From: Plant, Tom - Communities <Tom.Plant@Oxfordshire.gov.uk>
Sent: 10 February 2020 11:41
To: Bob Neville
Cc: DC Support; Nichols, Chris - E&E; Cllr Arash Ali Fatemian
Subject: 19-02691-F - Land East Of The Leys Adderbury - Consultation Response
Attachments: 19-00619-F - Land East Of The Leys Adderbury

Ref.: 19/02691/F
Address: Land East Of The Leys Adderbury
Proposals: Erection of 3 dwellings - (revised scheme of 19/00619/F)

SITE LAYOUT PLAN

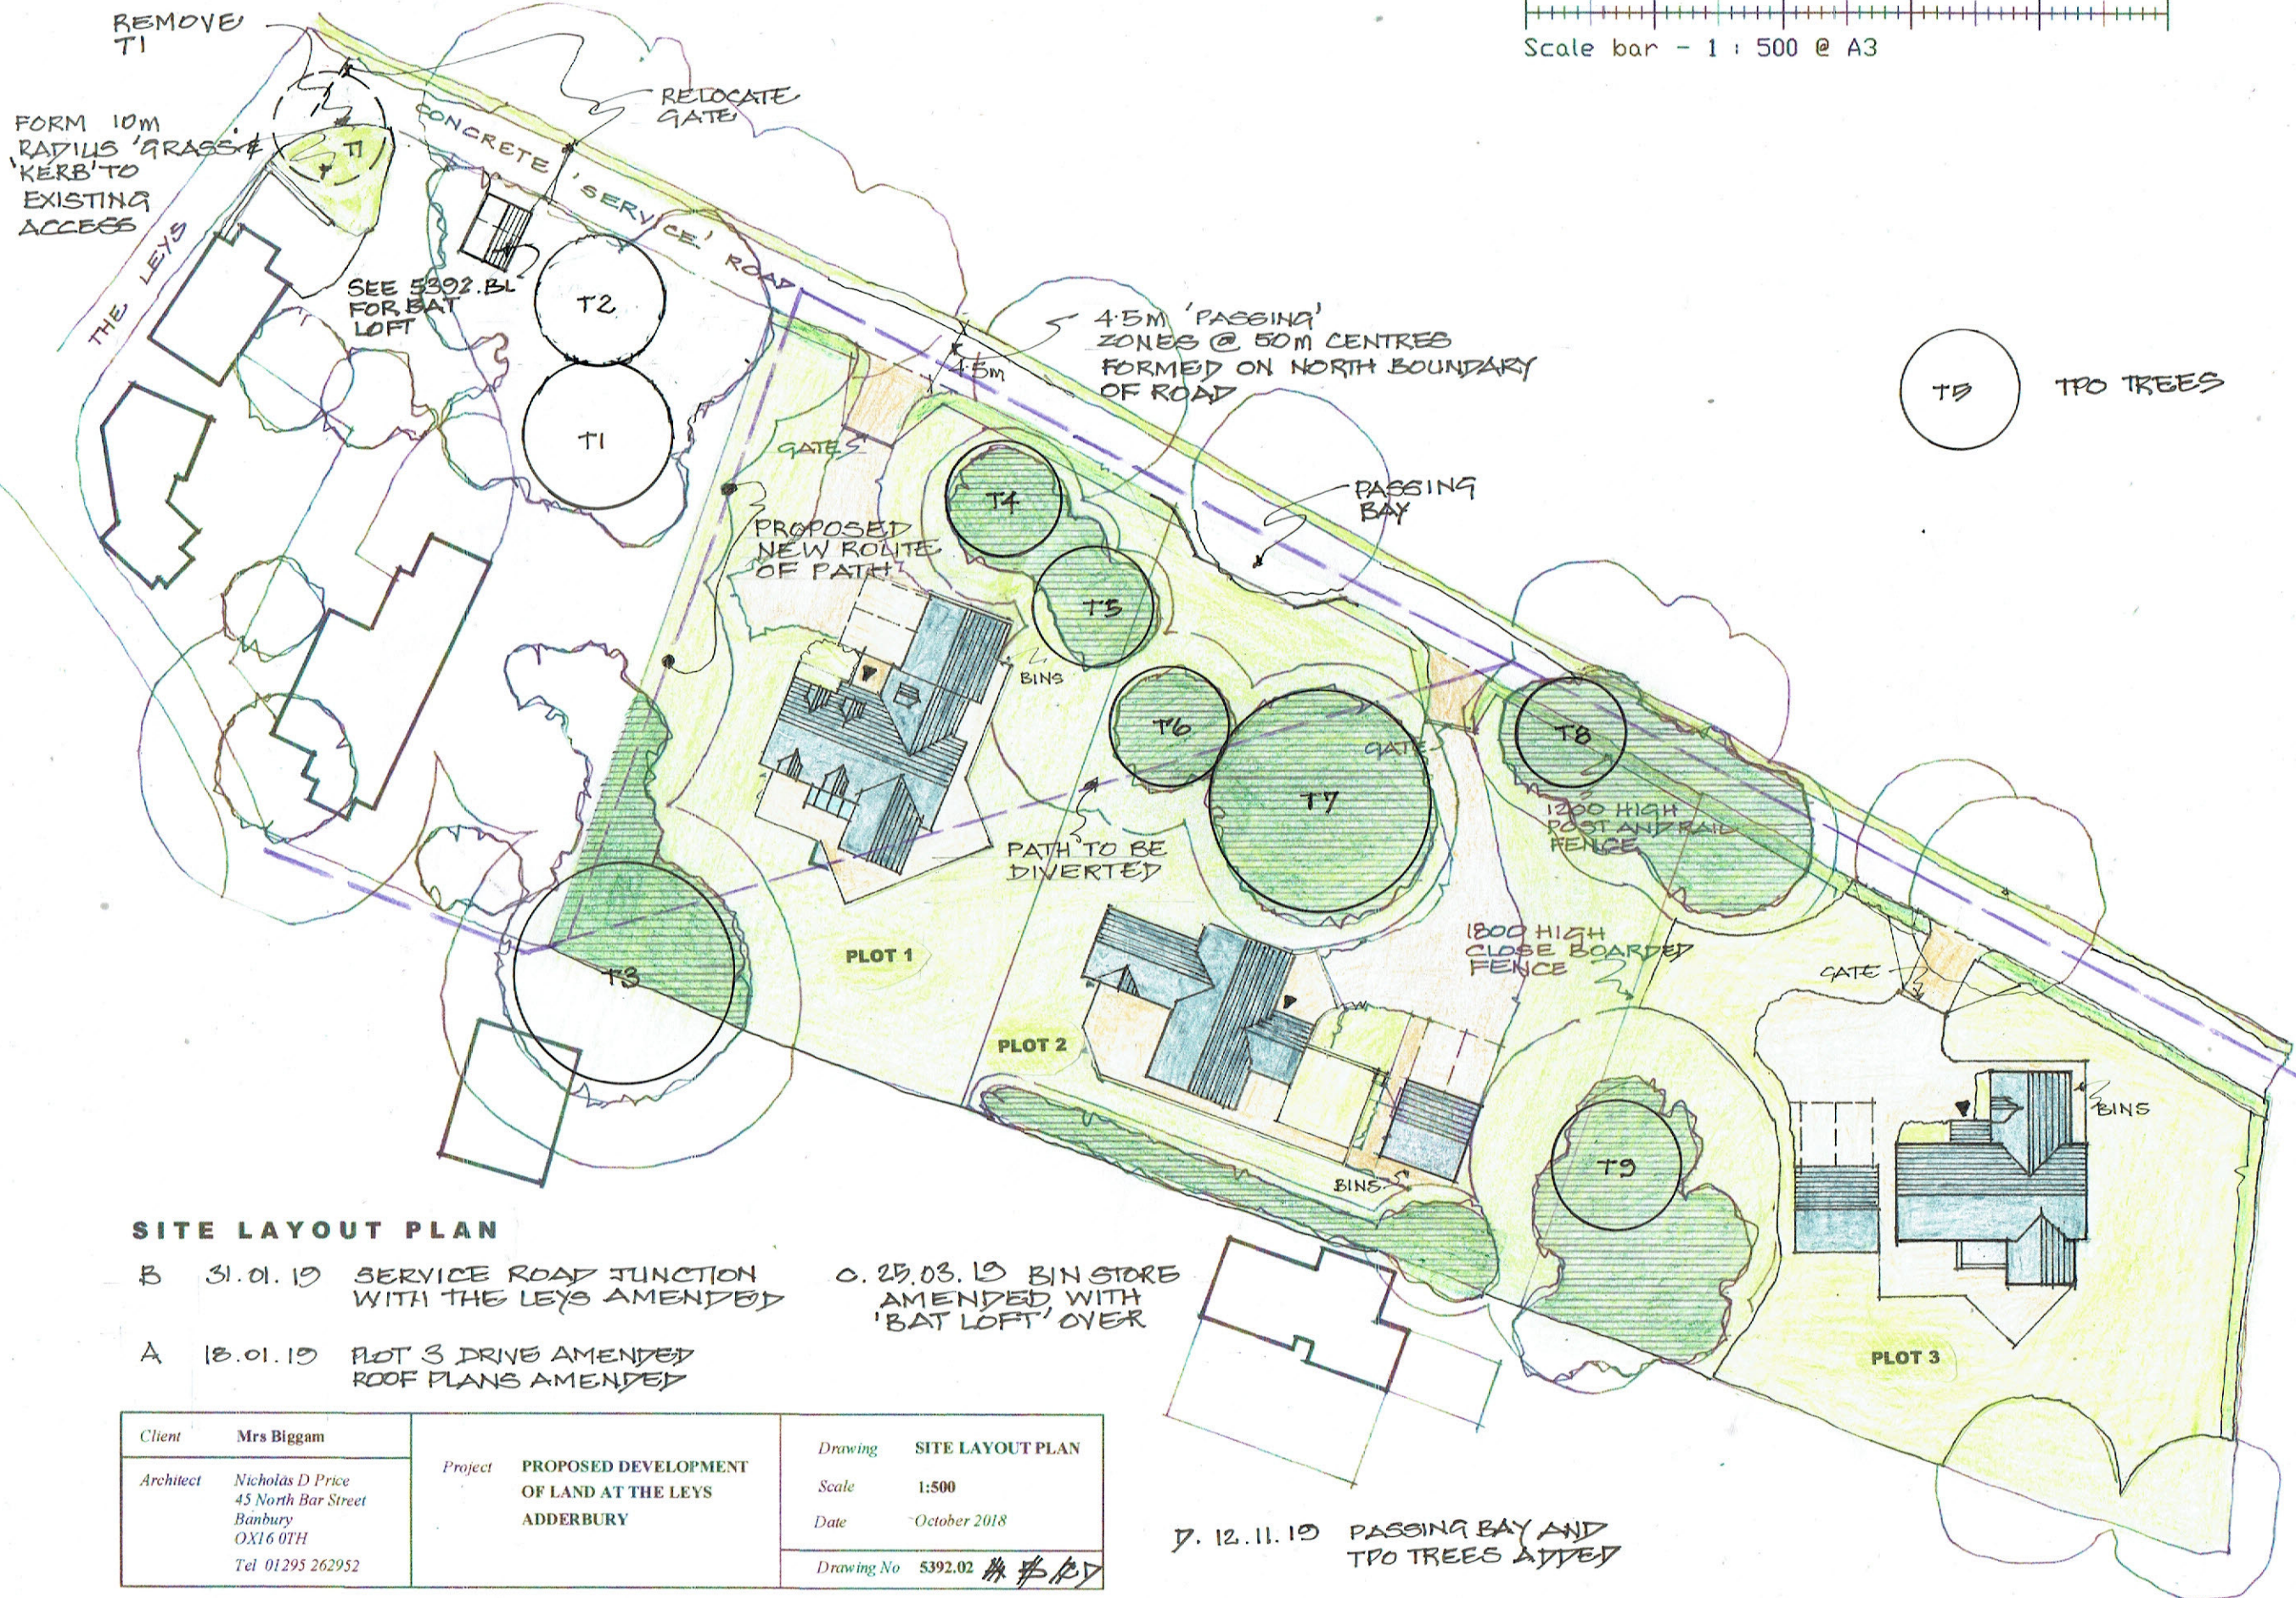
I have looked at the previous submissions site layout and I cant see any obvious differences between it and the one proposed here other than a new passing bay.

The passing bay that has been proposed between plots 1 and 2, its benefit will be limited if at all given its very close proximity to the northern bay. If the applicant wanted to resolve this and make access to dwellings 2, 3, TW site as well as the PROW more attractive and safer for vehicles access / egressing the applicant appears to have sufficient land within the proposed curtilages to make the track wider without comprising on the overall desirability of the plots proposed.

However the principal area of concern is the first section of the track that leads to the near 90 degree bend that leads onto the proposed dwellings. I see from the site location plan that at the point the red line meets the adopted highway the redline flares out. Nonetheless, should two vehicles meet each other, one **will be** forced to give way to the other and travel in a reverse gear either back towards the 90 degree bend, reverse back out into the adopted highway or use third party land to pull into. None are attractive options or even safe, and without third party land owners permission this option will not be possible and or could cause conflict.

If the proposal were to be approved, given the items outlined above, how does the applicant intend to get construction traffic to and from the site safely?

Finally, I have spotted the proposed refuse store and bat loft which I didn't comment on previously. I doubt from looking at the layout plan that refuse lorry can access and egress the store in a forward driving gear – let alone access it in the first places (no tracking diagram). I would be interested to know if the refuse lorry serves the other dwellings off this access track considering this is not part of the adopted network.

Given what I have highlighted above and that I see no other obvious differences other than a new passing bay between the previous scheme the previous objection (attached) still applies with the added points bolstering the objection.
